City of Albuquerque

May 10, 1999

Re: Los Prados del Norte - Unit 1, File No. D16/D8, engineer's stamp
dated April 7, 1999.

TITLE: **LOS PRADOS DEL NORTE**
GRADING AND DRAINAGE PLAN

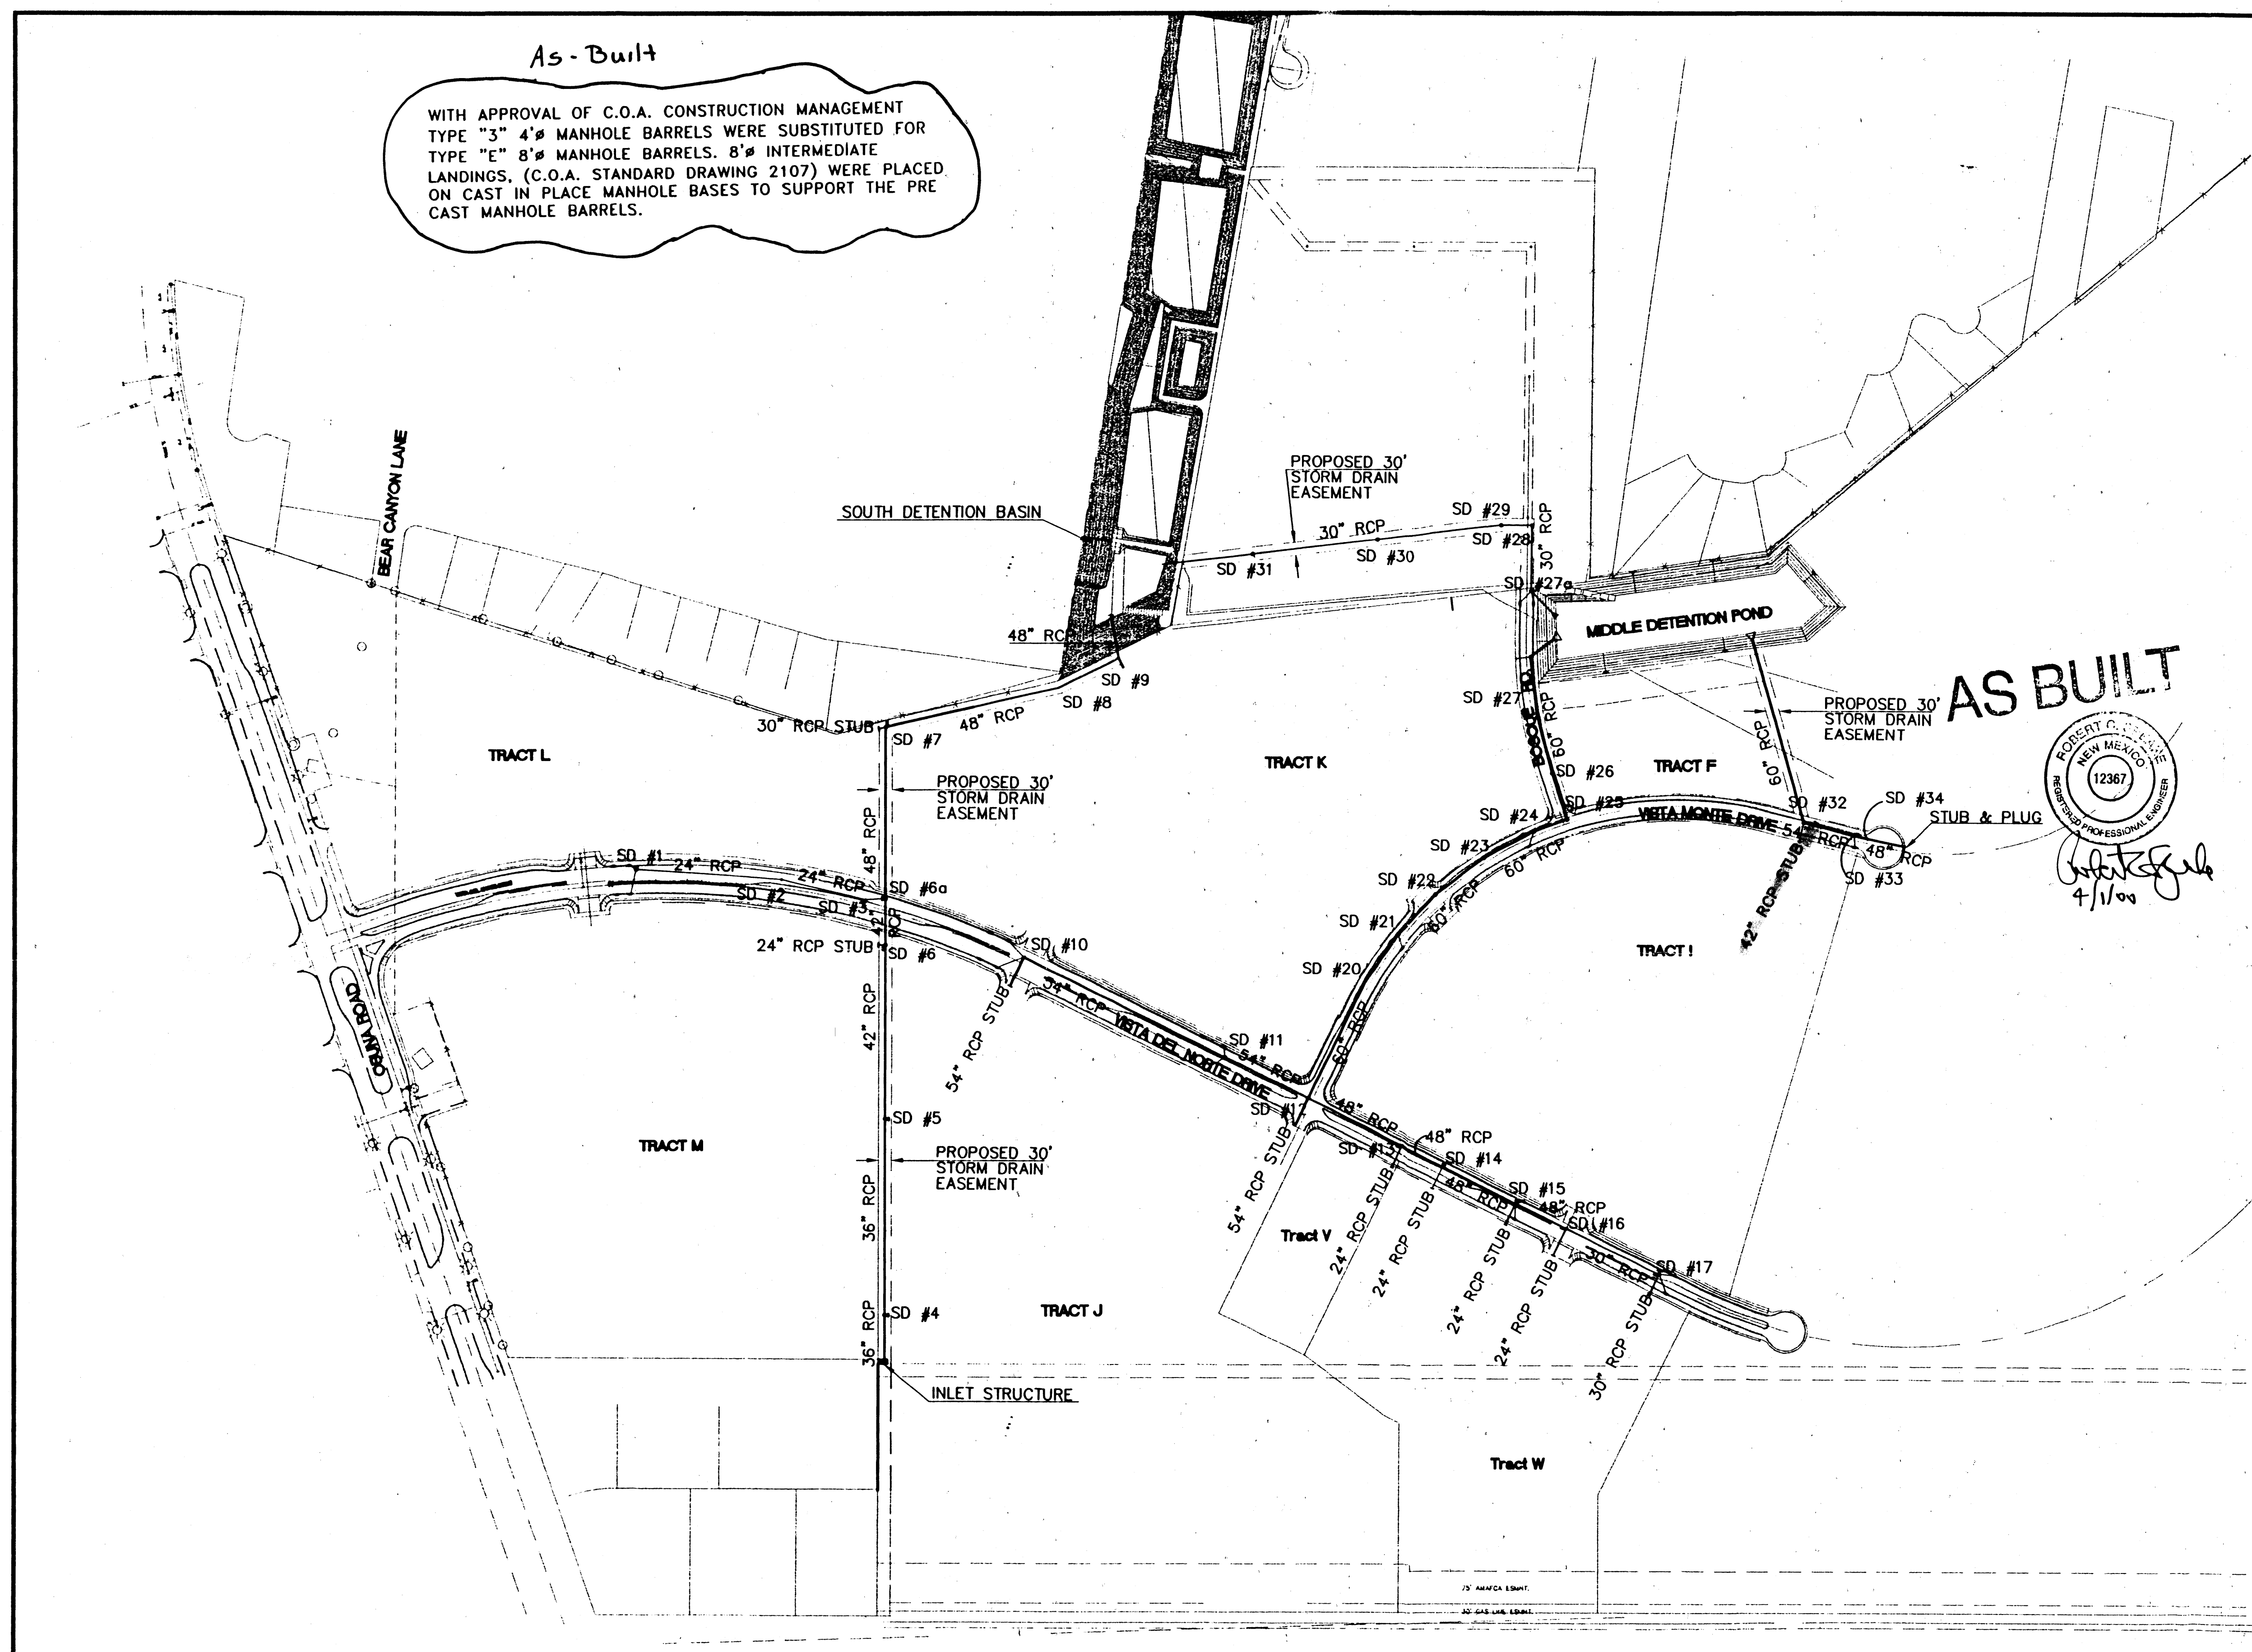
It is not clear from your letter dated April 7, 1999 what is considered the spillway that is to be maintained by the Homeowner's Association. Please provide a cross-section clearly indicating the 6' public channel, water line, private access, spillway and landscaping proposed within the 25' easement. Keep in mind that the 6' channel must be in an exclusive drainage easement, no private access will be permitted within this easement. Storm Drain Maintenance signature will be required for DRC approval.

City Project No. 5970.81	Zone Map No. D-16-Z & E-16-Z	Sheet 36a	Of 90
-----------------------------	---------------------------------	--------------	----------

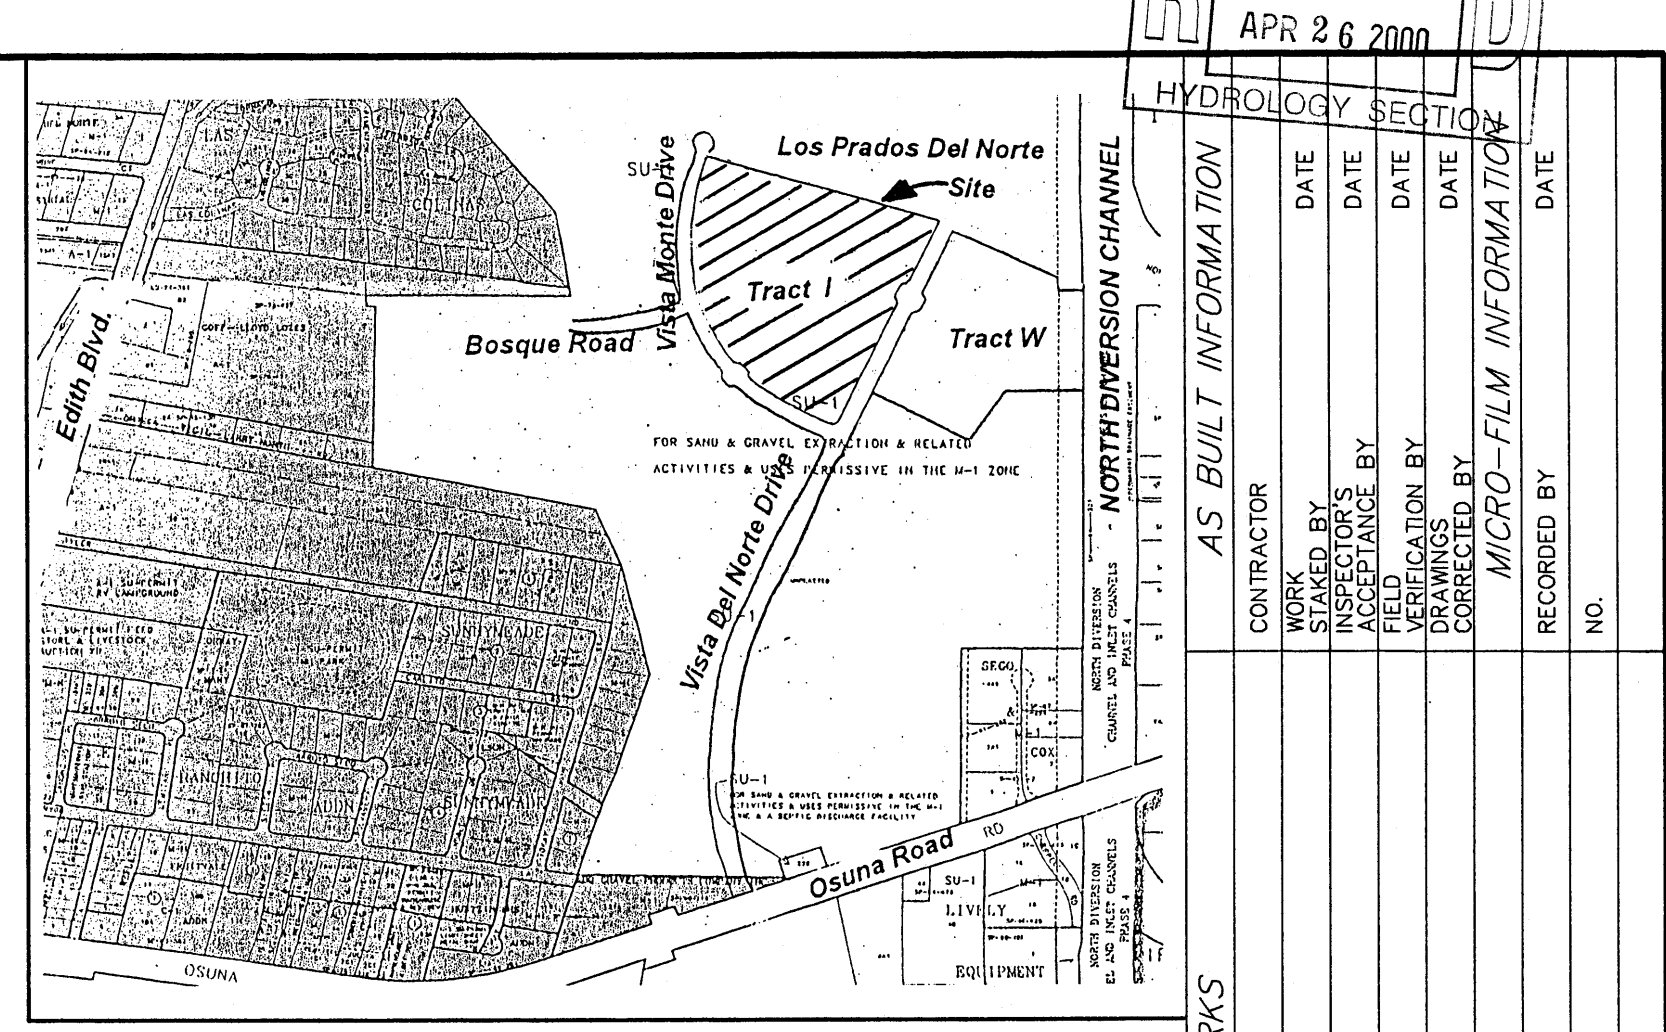
Regarding the proposed storm drains to be upsized off-site, it is understood that you will coordinate these changes with Parsons-Brinkerhoff. Prior to DRC approval the revised plan and profile sheets for the off-site storm drain must be submitted to this office to verify that the HGL is below the street grade. The required certification to release the SIA and financial guarantees will require documentation that these changes took place.
